Response to Department of Planning Comments

Key Issue 1
GFA and building height exceedances

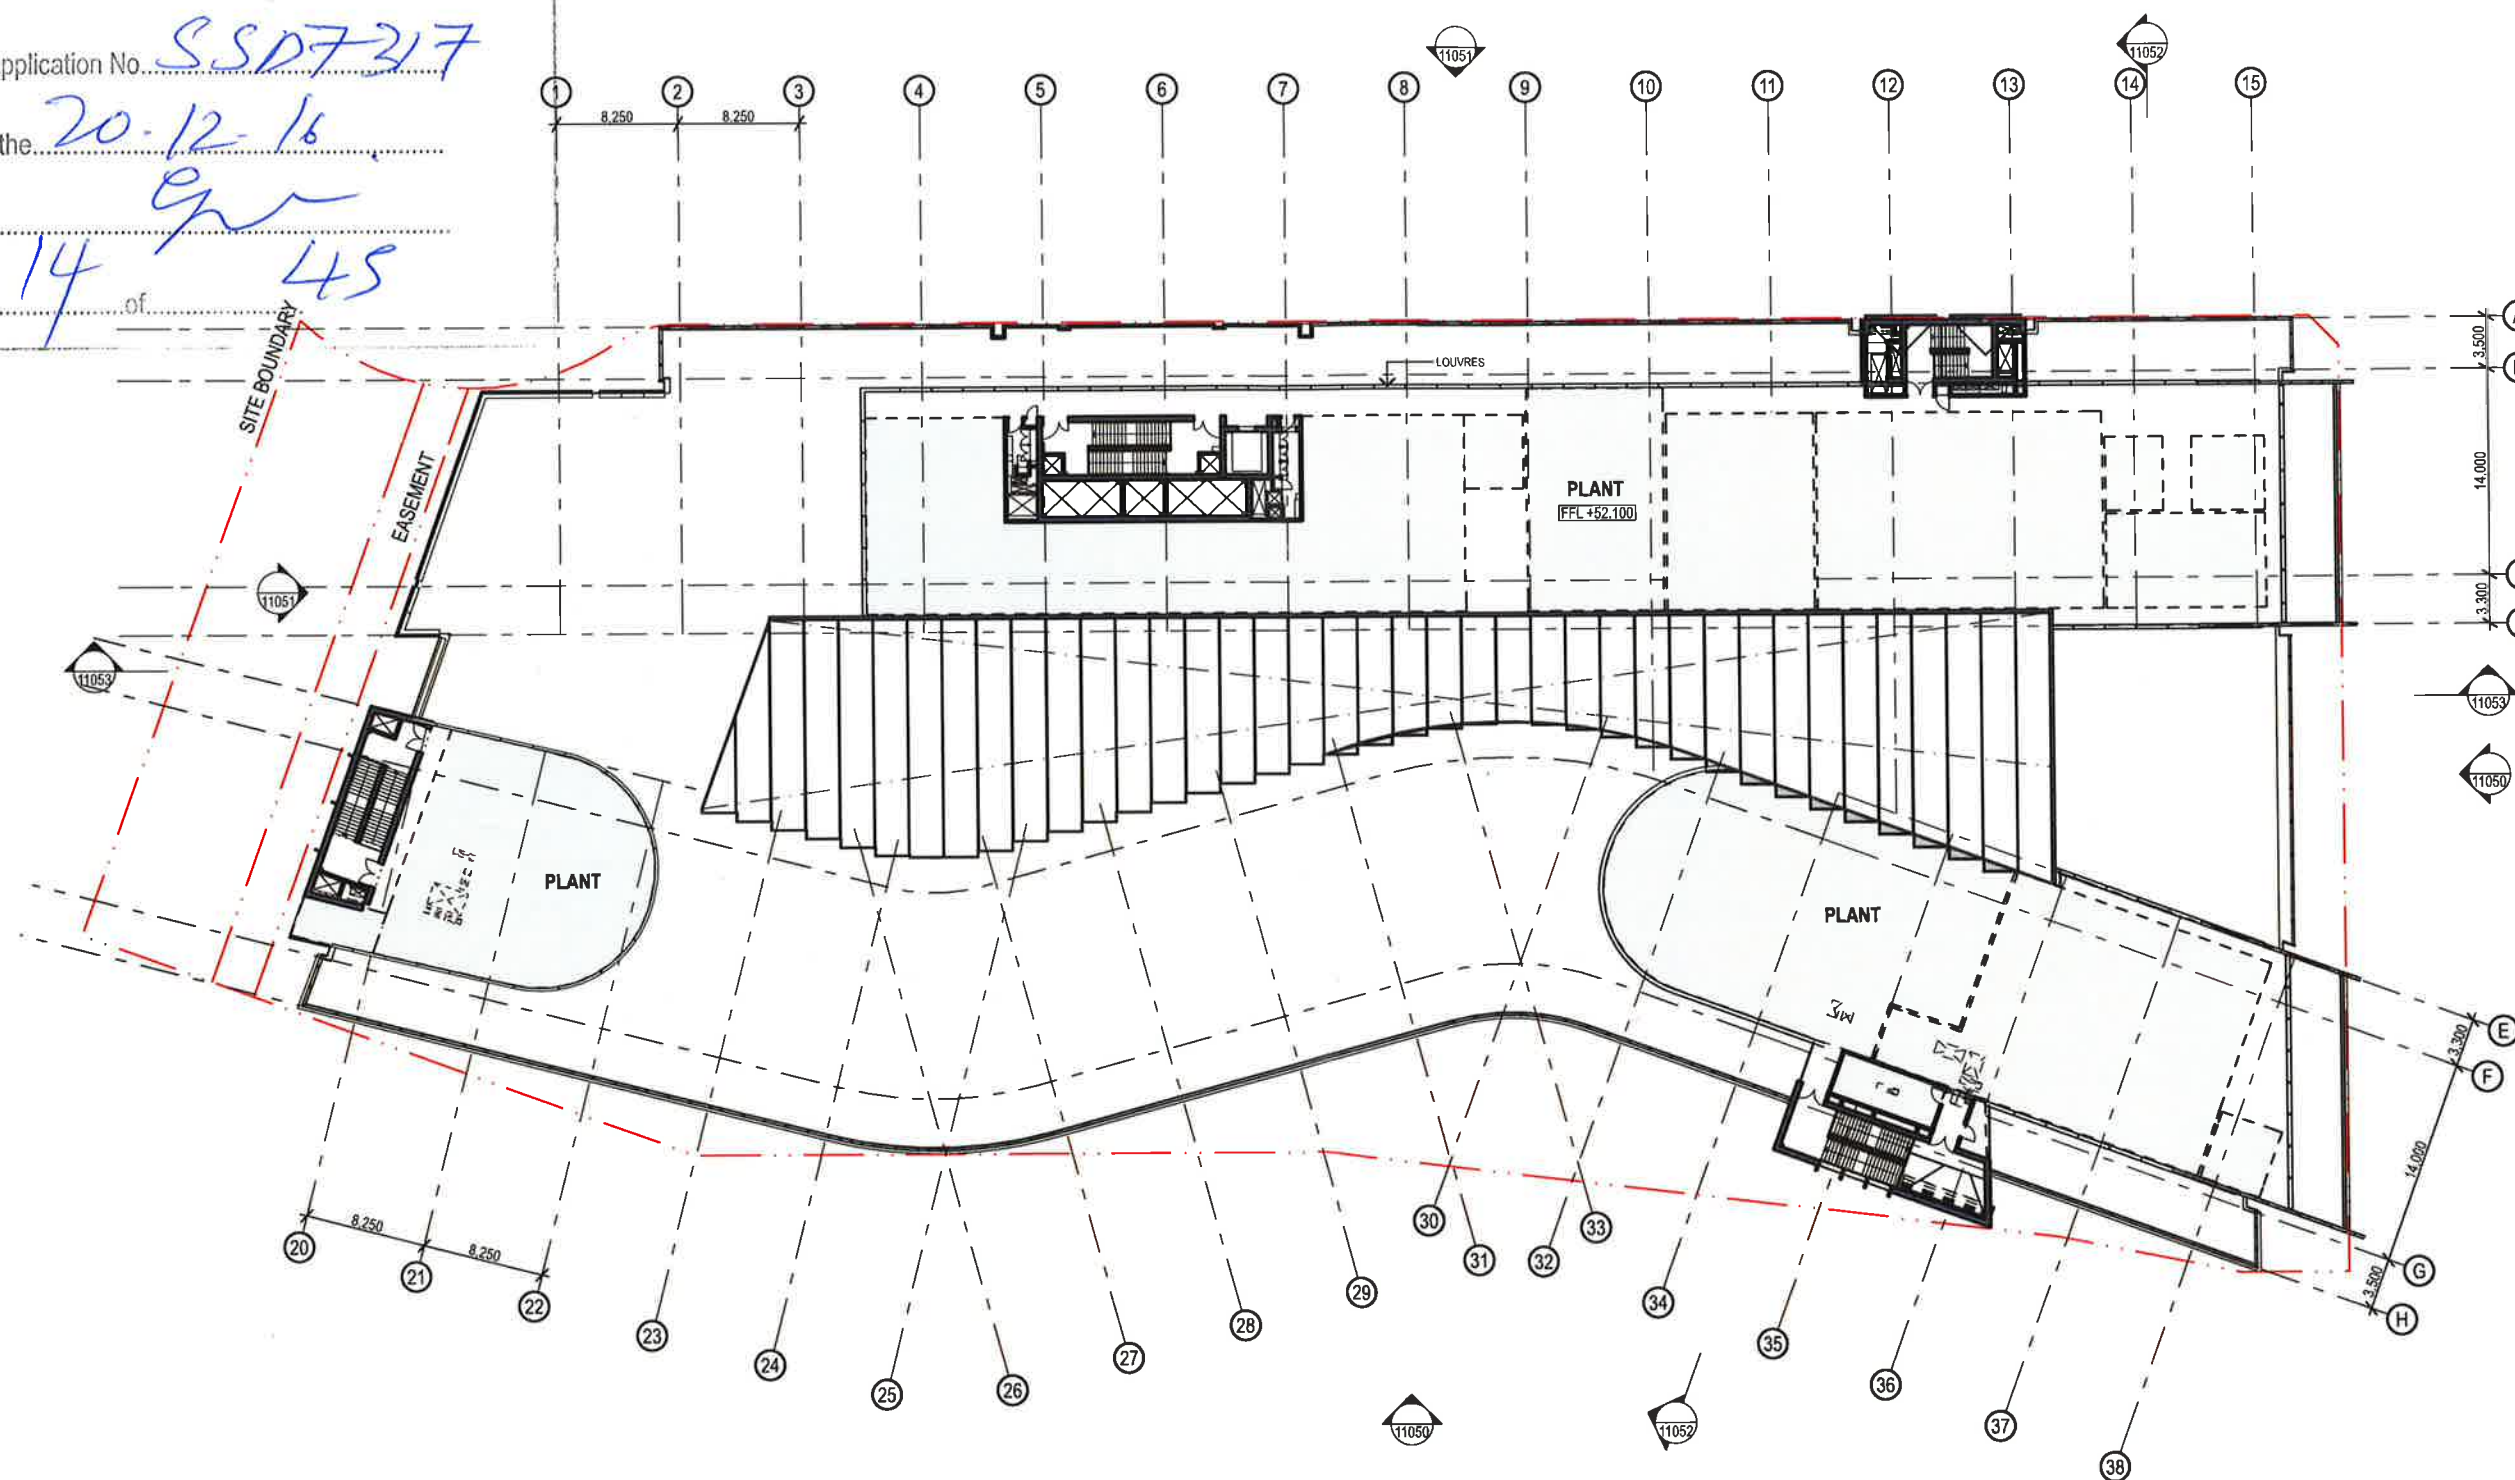
Further clarification and justification is required to support the proposed rooftop plant, including:

- rooftop plant, except 'a lift room, stairs or meter room', is considered a storey for the purposes of calculating building height in accordance with the MD SEPP;
- the shadow diagrams should include overshadowing impacts of the rooftop plant on neighbouring properties, if not already done so;
- further justification is required to support the rooftop plant proposed on building 1 and 2, including the function of the plant, and consideration should be given to rationalising the extent of rooftop plant and relocating any necessary plant so as not to adversely impact on the visual quality of the building and overshadowing impacts on neighbouring properties.

- further justification is required to support the rooftop plant proposed on building 1 and 2, including the function of the plant, and consideration should be given to rationalising the extent of rooftop plant and relocating any necessary plant so as not to adversely impact on the visual quality of the building and overshadowing impacts on neighbouring properties.

- *The extent and height of the B1 plantrooms has been reduced relative to the original SSDA submission. Through redesign, 330sqm of roof top plant has been removed from B1. Through relocation of taller elements of plant to other areas the roof top area of plant associated with the south west core has been reduced in height from 5.8m to 4.0m. This reduction in roof plant reduces the extent of overshadowing to Henderson Road and provides additional solar access to the Henderson Road residences. The remaining areas of roof top plant as allocated to the roof of Building 1 and 2 are essential and have functional requirements to be located on the roof.*
